Application Ref:	2025/0603			 Ribble Valley Borough Council www.ribblevalley.gov.uk
Date Inspected:	N/A	Site Notice:	N/A	
Officer:	SK			
DELEGATED ITEM FILE REPORT:				NMA APPROVAL

Development Description:	Non-material amendment to application 3/2024/0990 involving change in window/door positions and change of materials on entrance elevation (stone instead of render).
Site Address/Location:	Barrowbridge House Club Street Barrow BB7 9AY

Client Mr S Gill		
Project Proposed Development at Barrow Bridge House Club Street Barrow Clitheroe BB7 9AY		
Drawing Title Plot 3 Proposed Plans and Elevations		
Scale 1:50/100 @ A2	Date Nov 2024	Drawn LFR
READ DESIGN LTD		
161 - 04 B

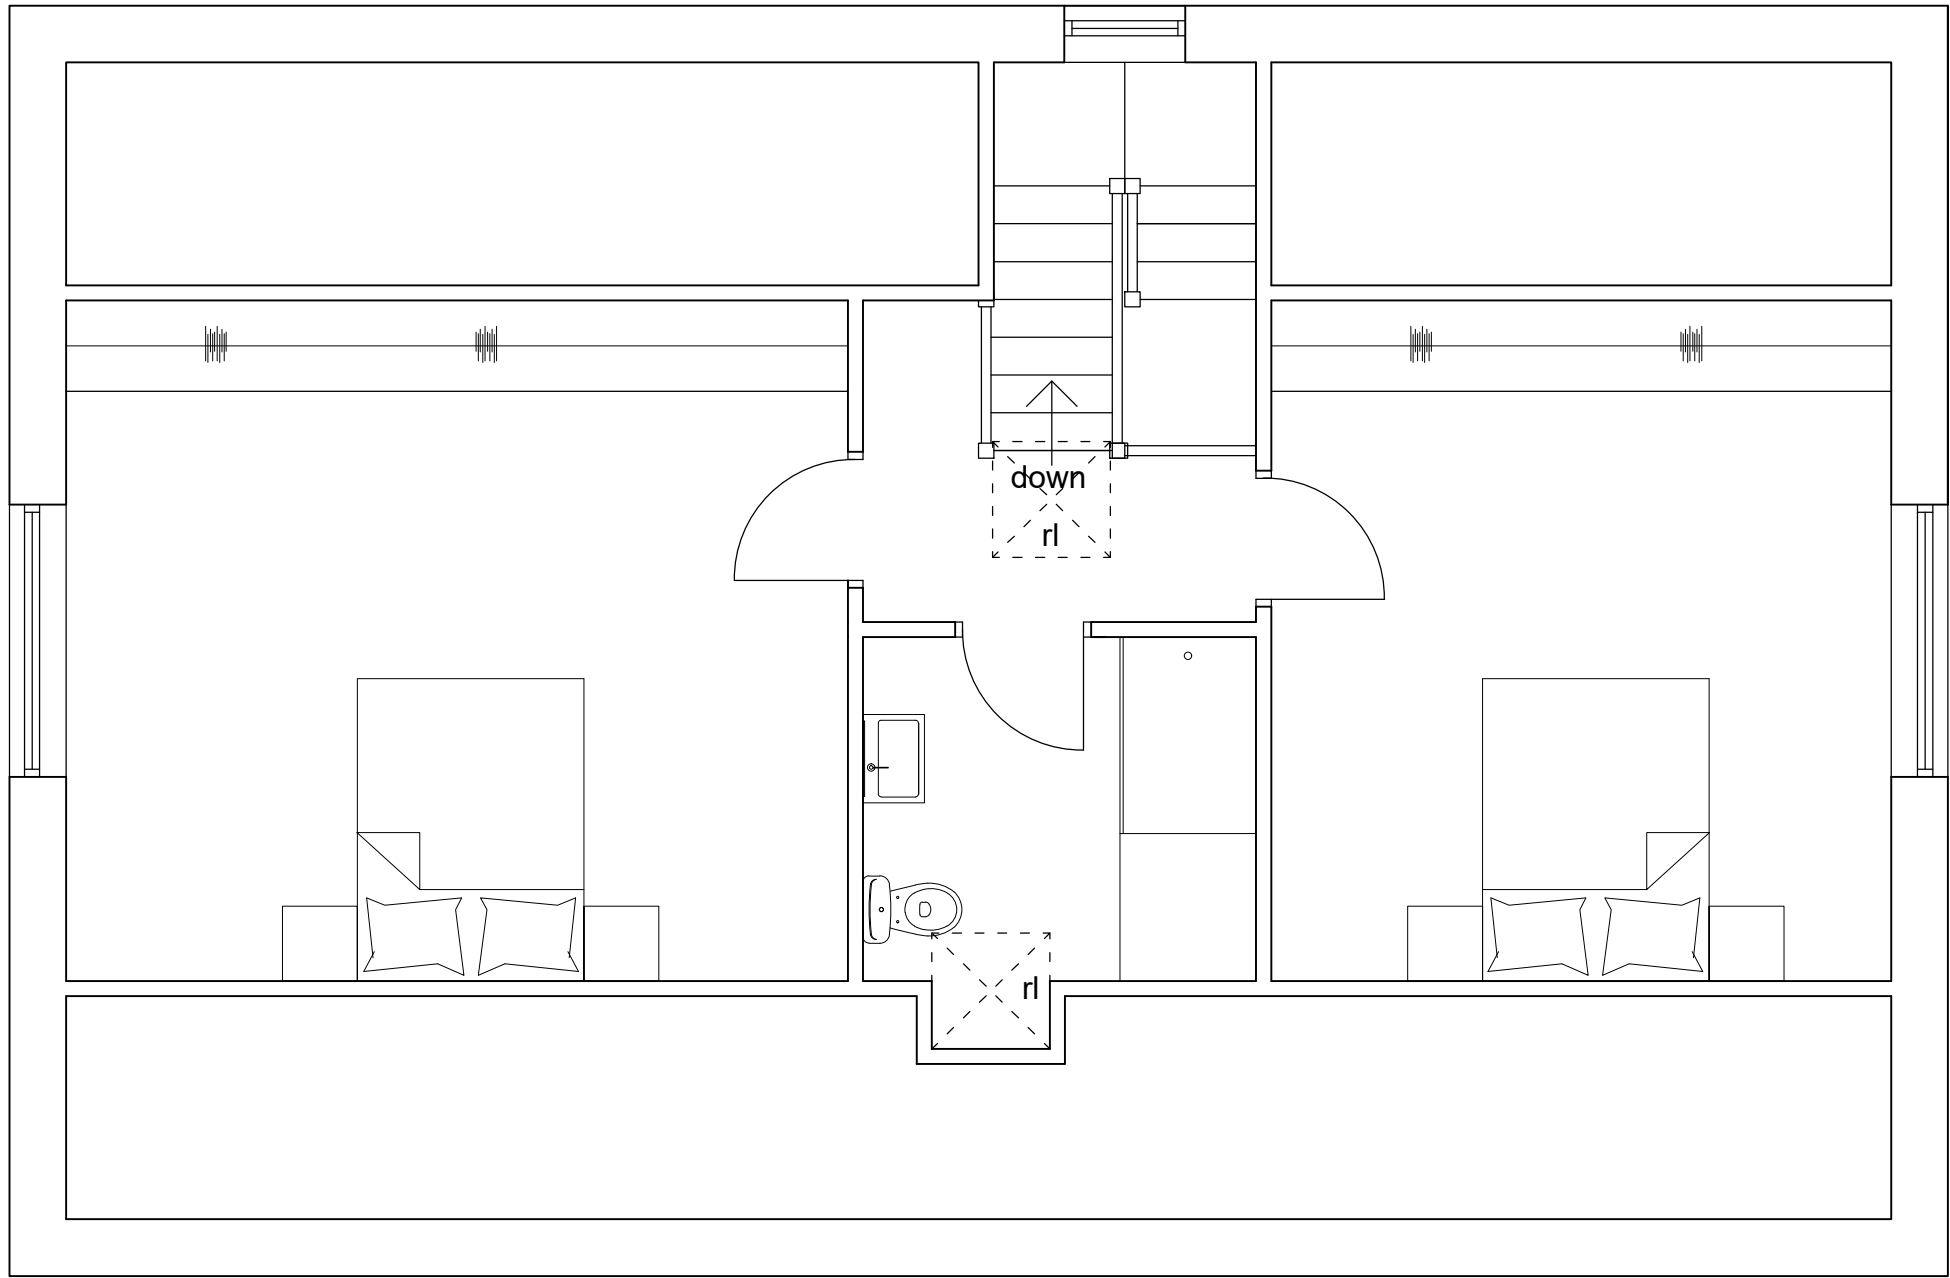
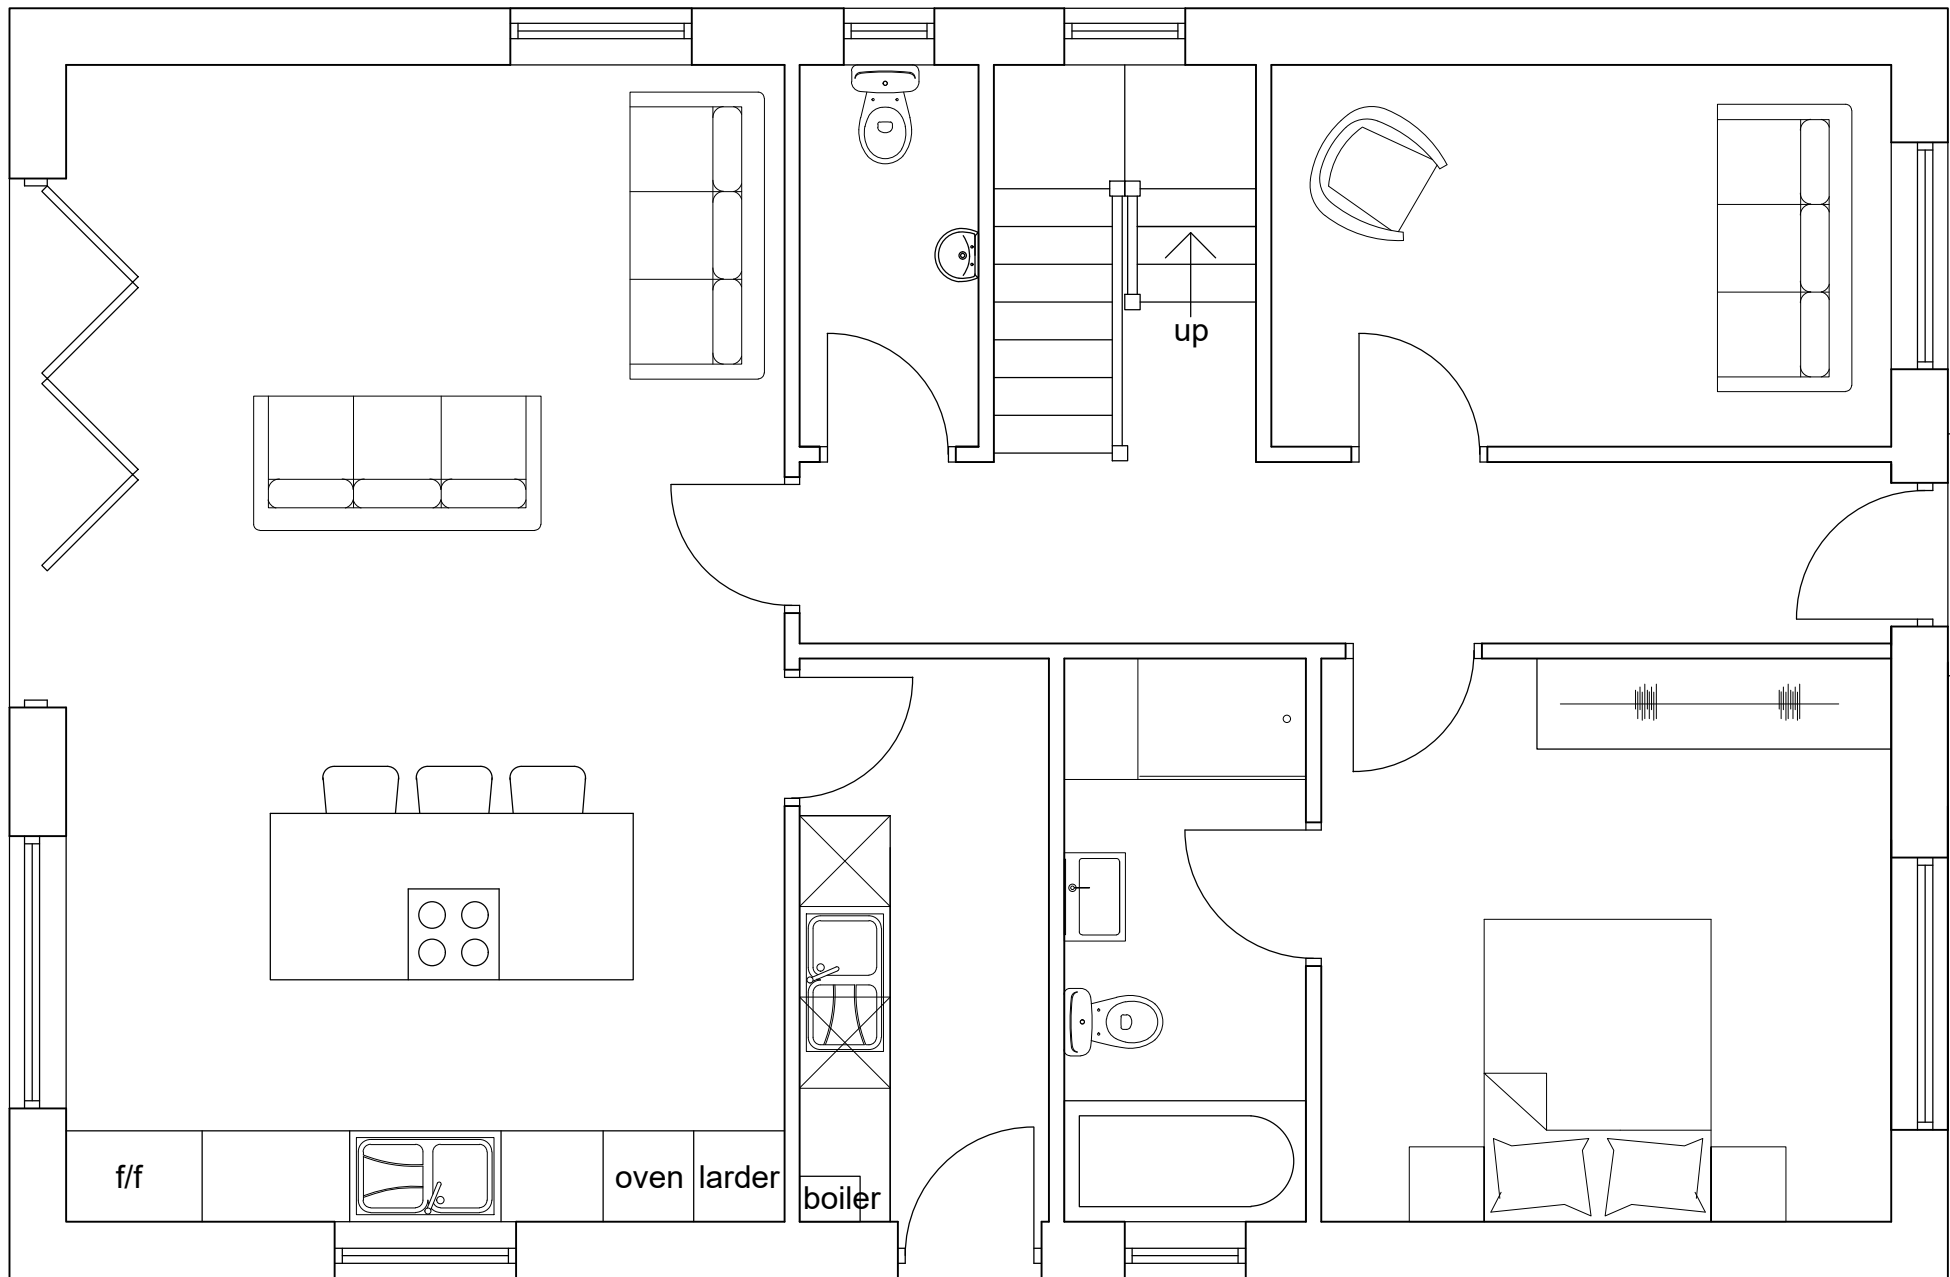
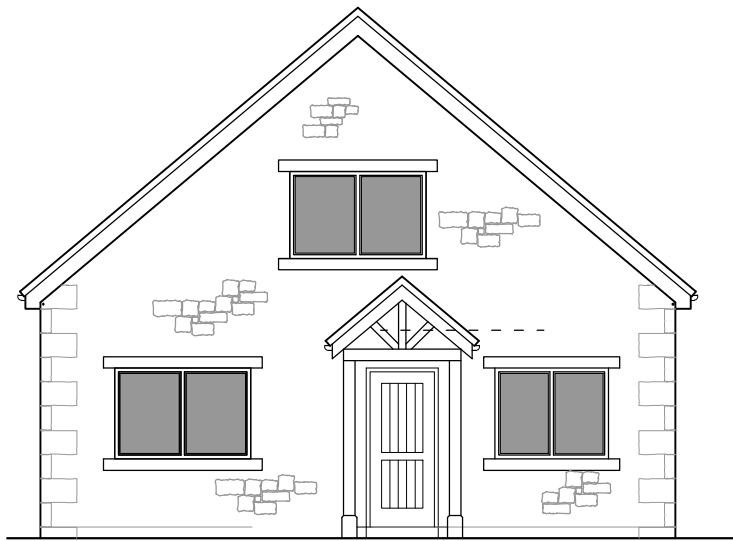
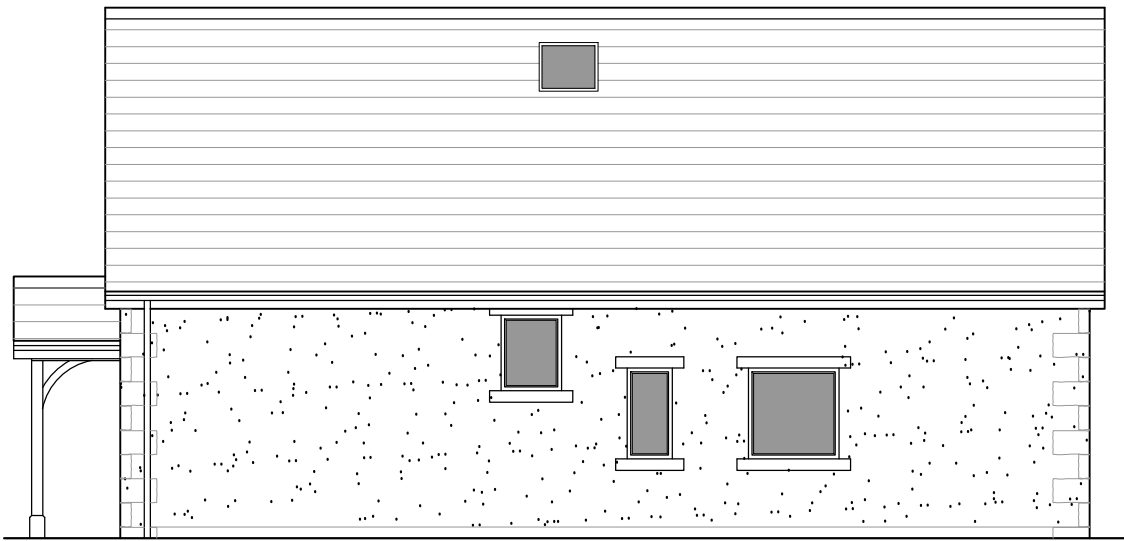
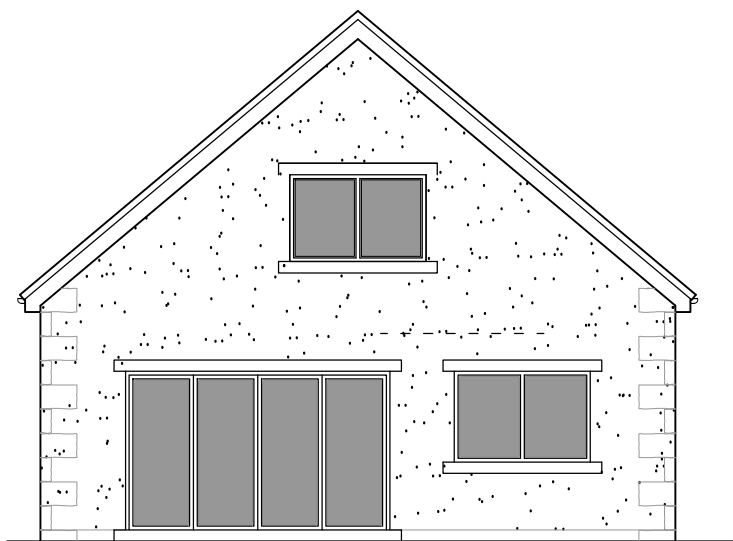
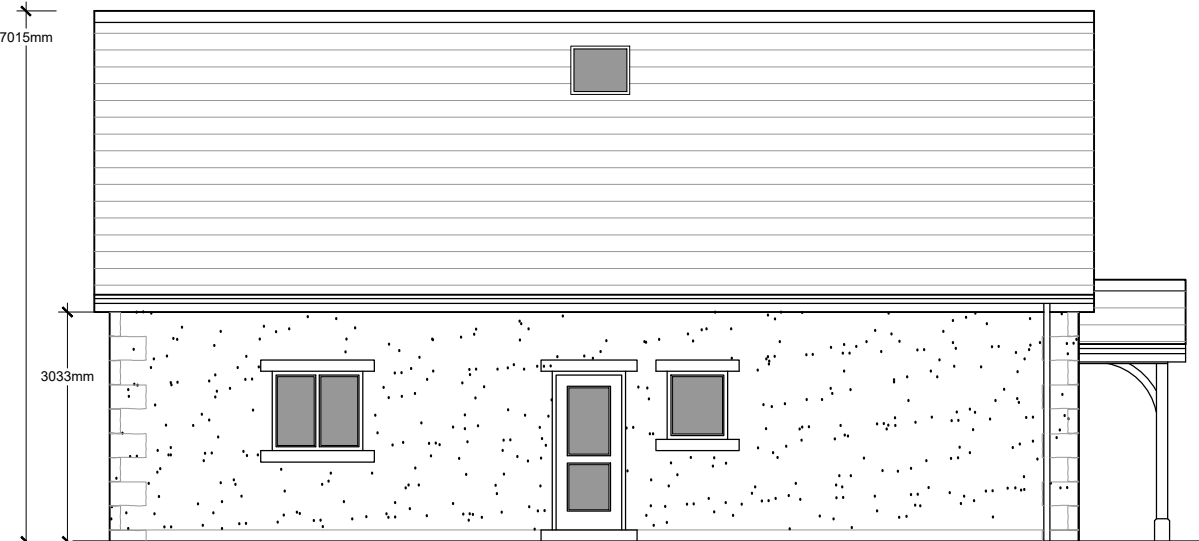
Plot 03:

North-East Elevation:

- Amendment to window locations and introduction of window to serve newly located internal staircase.
- Head and sill detailing added

North-West Elevation:

- Head and sill detailing added

South-East Elevation:

- Introduction of new window at ground floor
- Use of stone on elevation in-lieu of render
- Head and sill detailing added

South-West Elevation:

- Head and sill detailing added
- Window omitted

Internal Floorplan:

- Revised location of internal staircase
- Snug introduced at ground floor
- First Floor layout reconfigured
